BOVIS LEND LEASE

SITE 4B SYDNEY OLYMPIC PARK

ACCESS REVIEW

16th December 2010

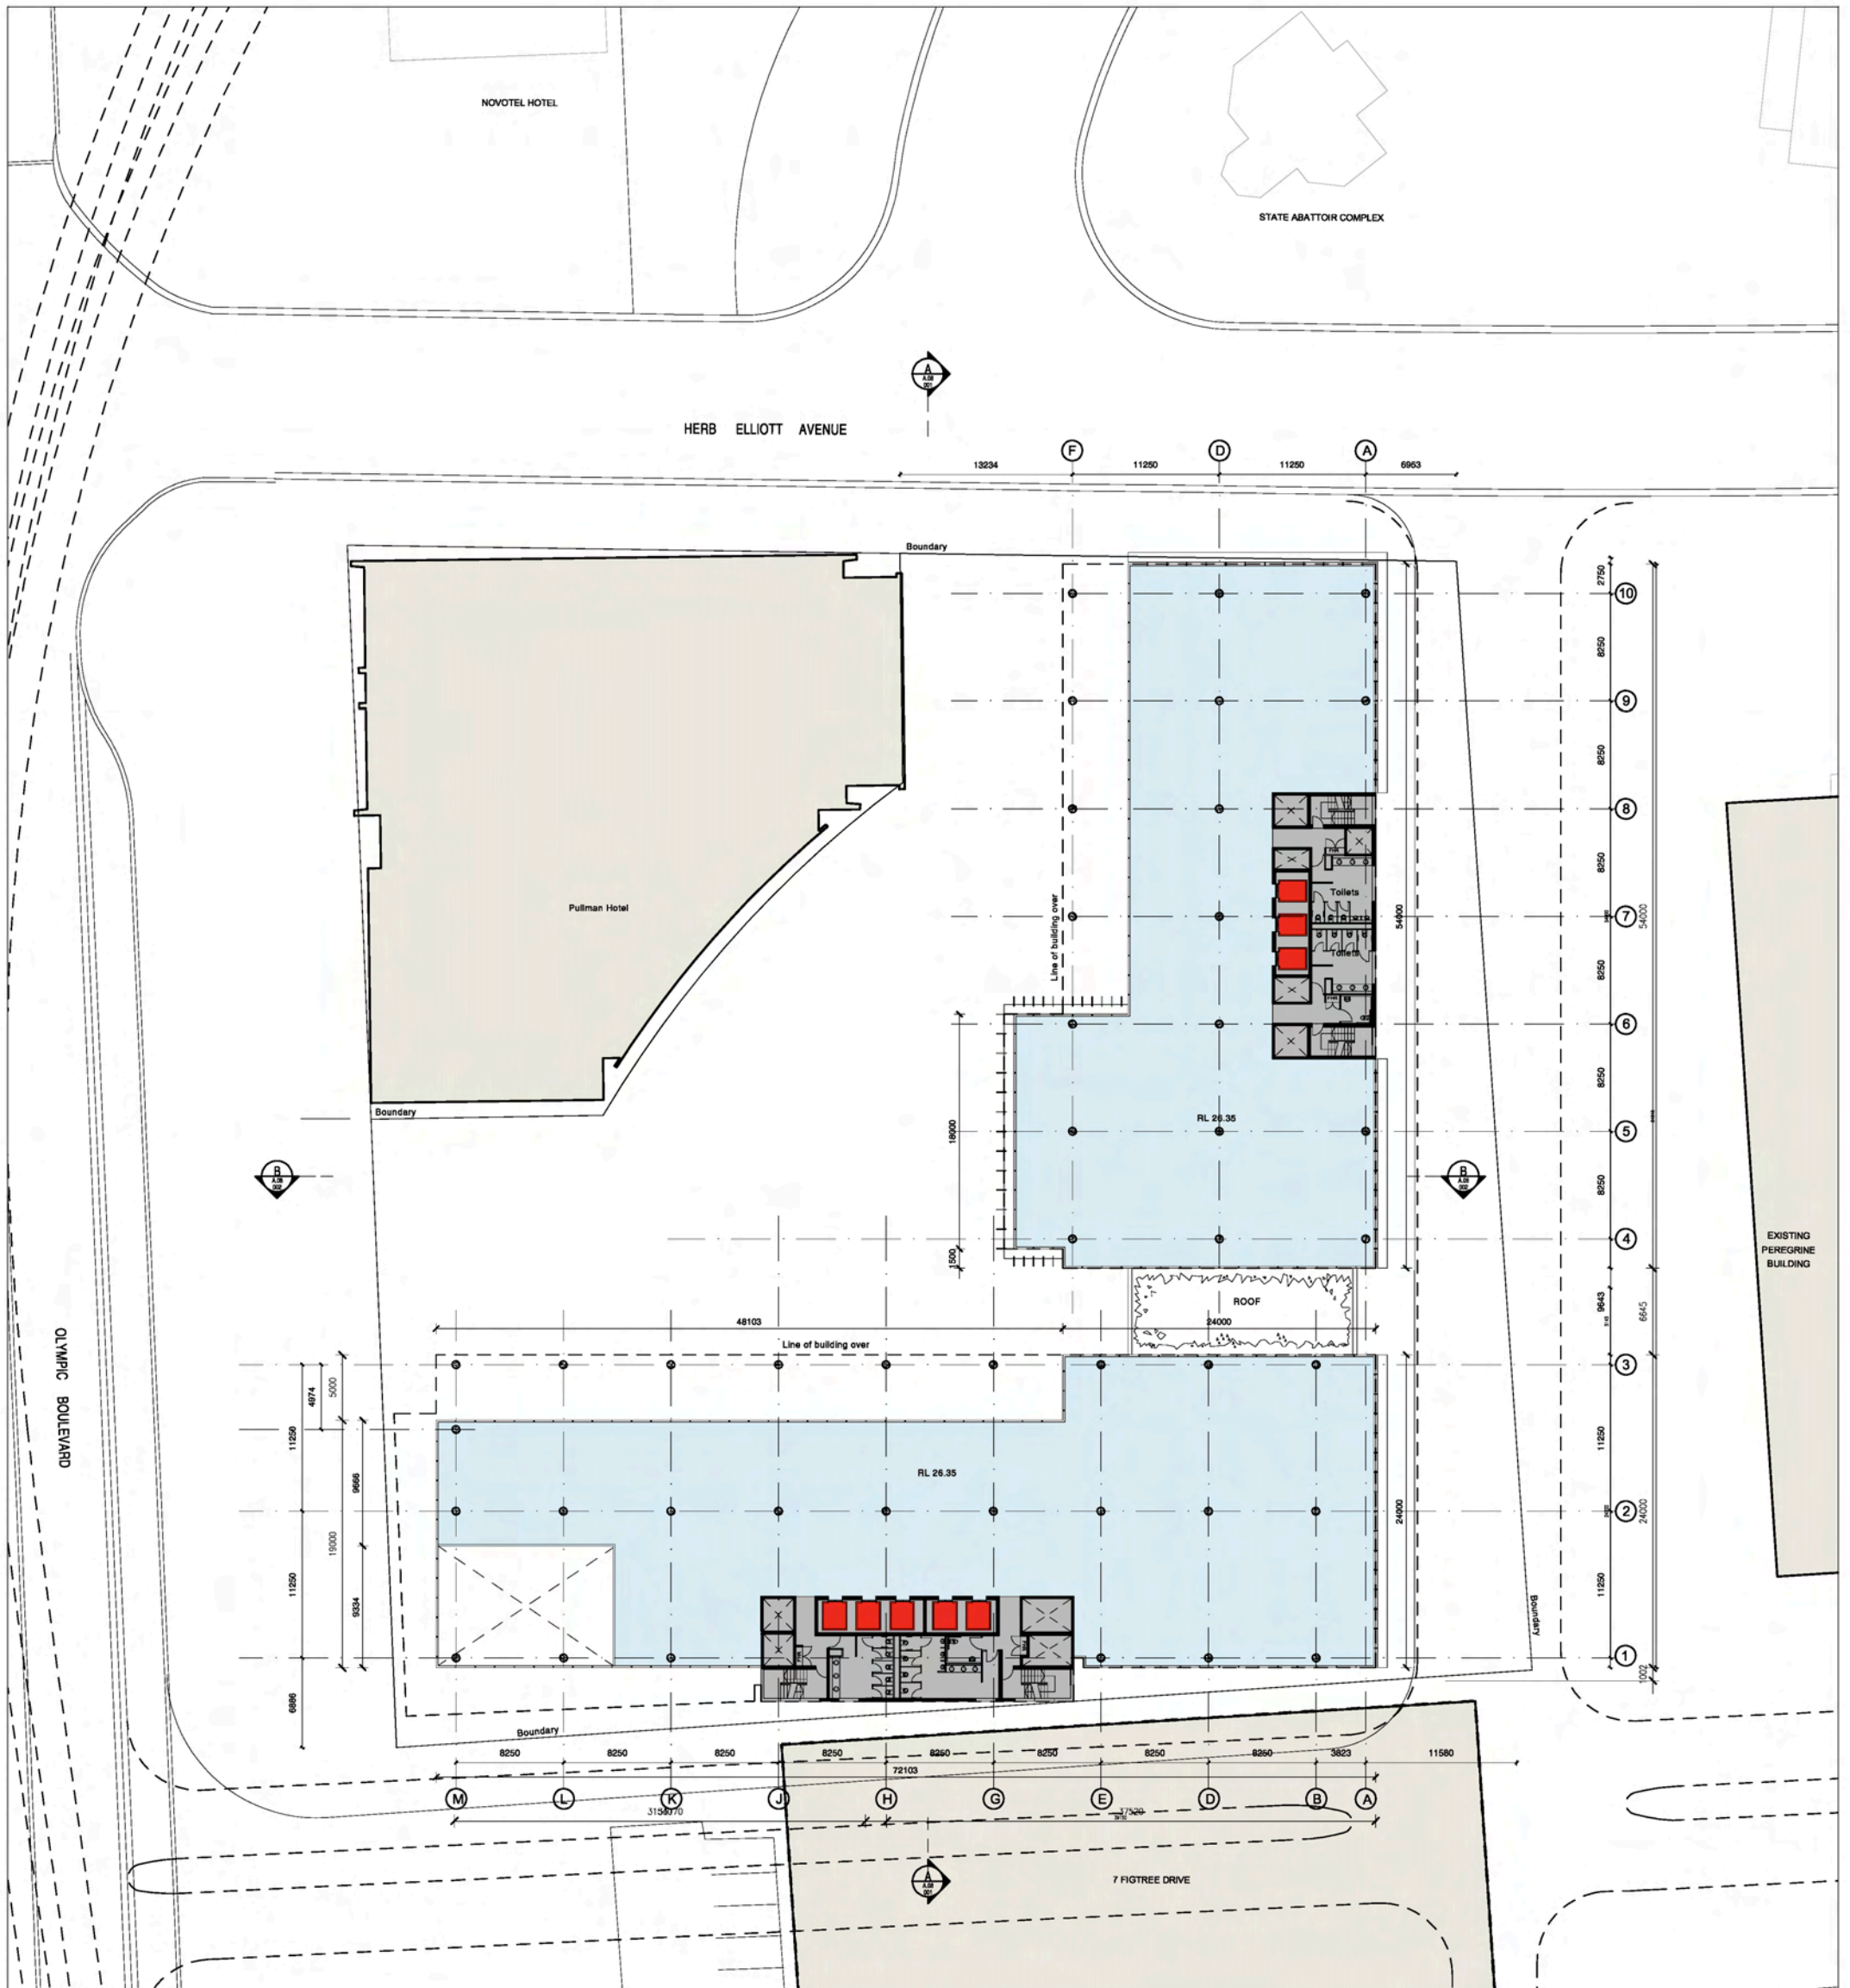
- (i) Relocate tree situated at the base of 1:20 walkway at grid ref. K4 to provide appropriate clearances at the base of walkway compliant with SOP Access Guidelines, clause 2.4. The tree currently appears to encroach into the landing area by 400mm.
- (ii) Provide handrails and TGSIs at stairs (grid ref. K4, E6 and E9) compliant with AS1428.1 and AS1428.4.

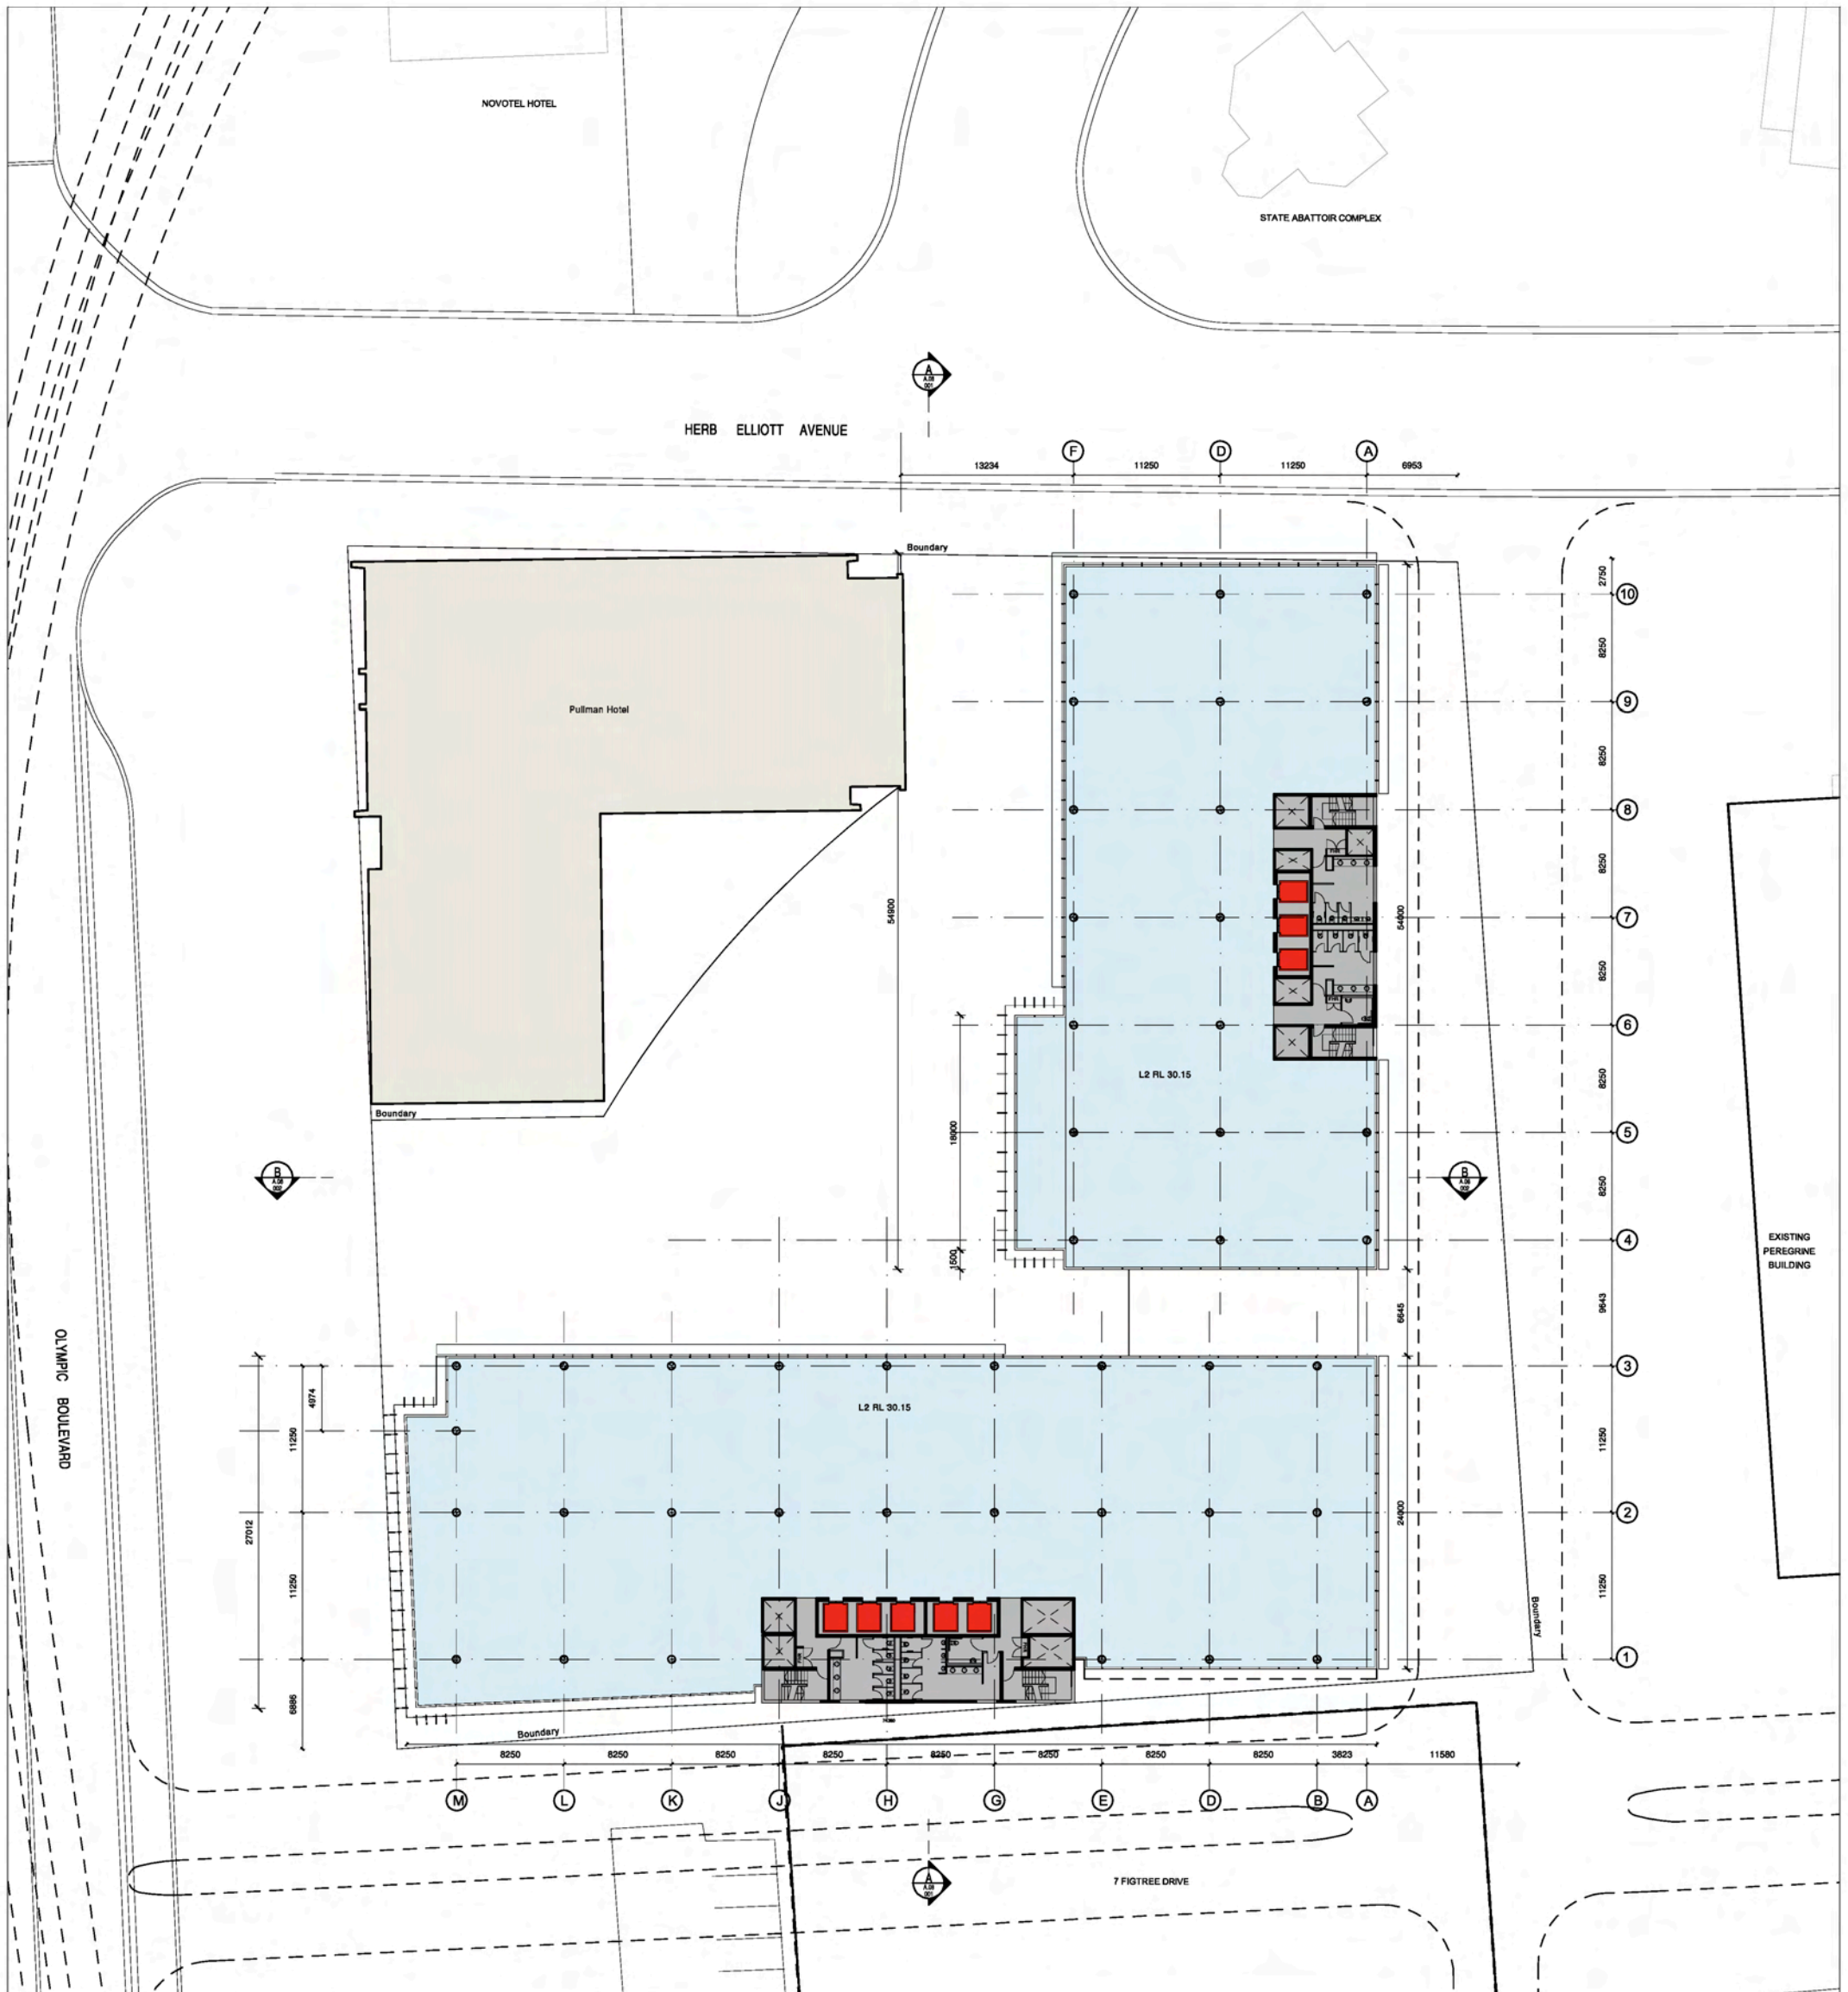
- (i) Enlarge accessible toilets on levels 01-07 to ensure a clearance of 2300mm x 1900mm around the pan compliant with SOP Access Guidelines, clause 16. The basin is to sit outside of this area.

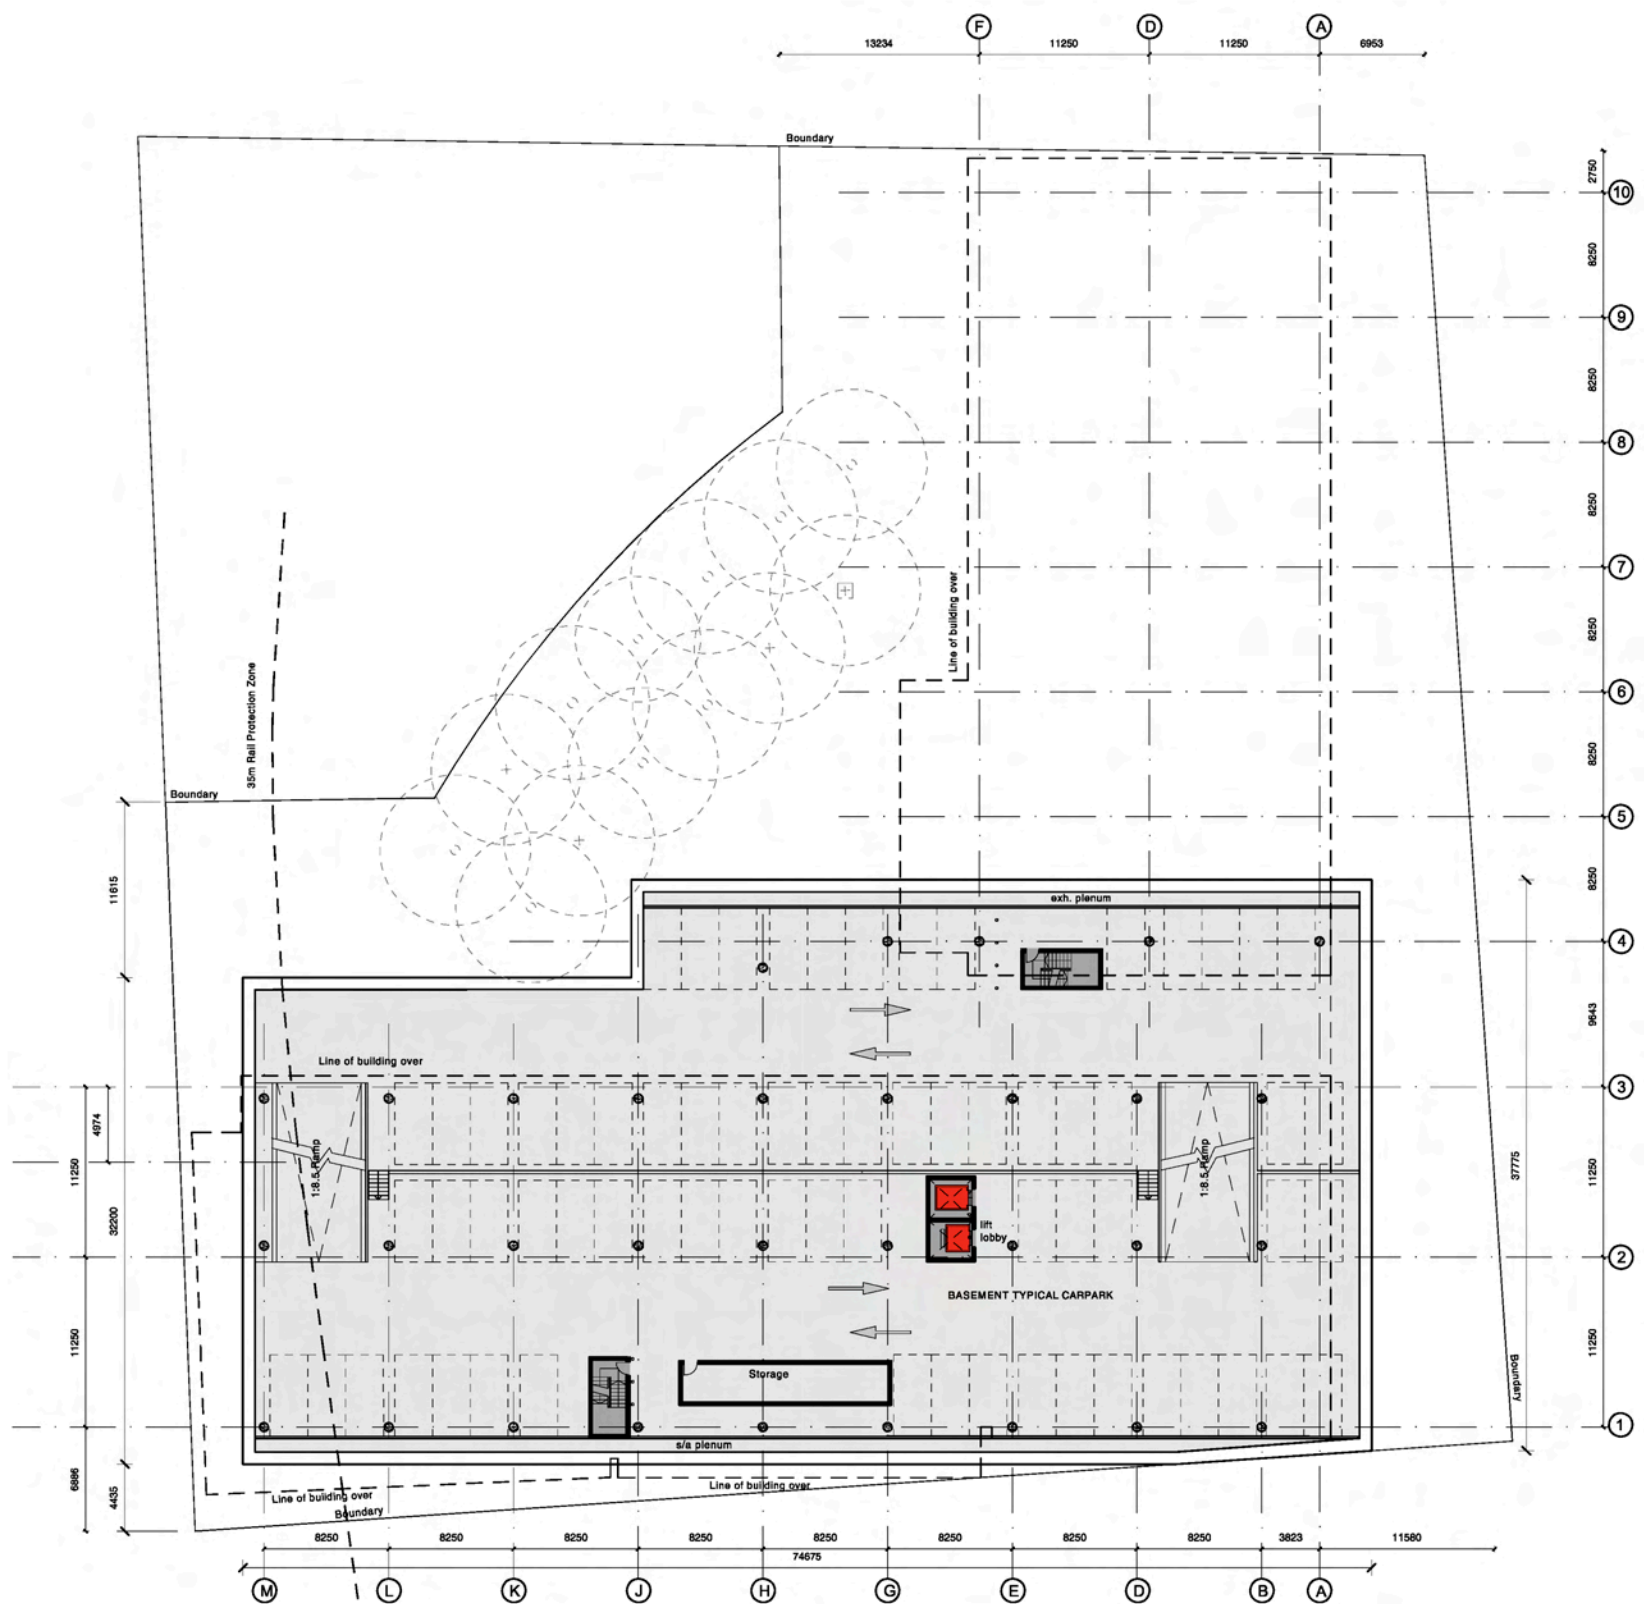
- (i) Provide 5 additional accessible car bays adjacent to the lift lobby with internal dimensions of 3.2m compliant with the SOP Access Guidelines, clause 7.3.
- (ii) Consideration to provide accessible car bays with 2.4m internal width adjacent a 2.4m shared zone with a bollard at the start of the shared zone compliant with AS2890.6 and the DDA Premises Standards.
- (iii) Each accessible car bay requires a height clearance of 2.5 metres.
- (iv) The approach to each adaptable car parking bay should not have vertical clearance of less than 2.2m.
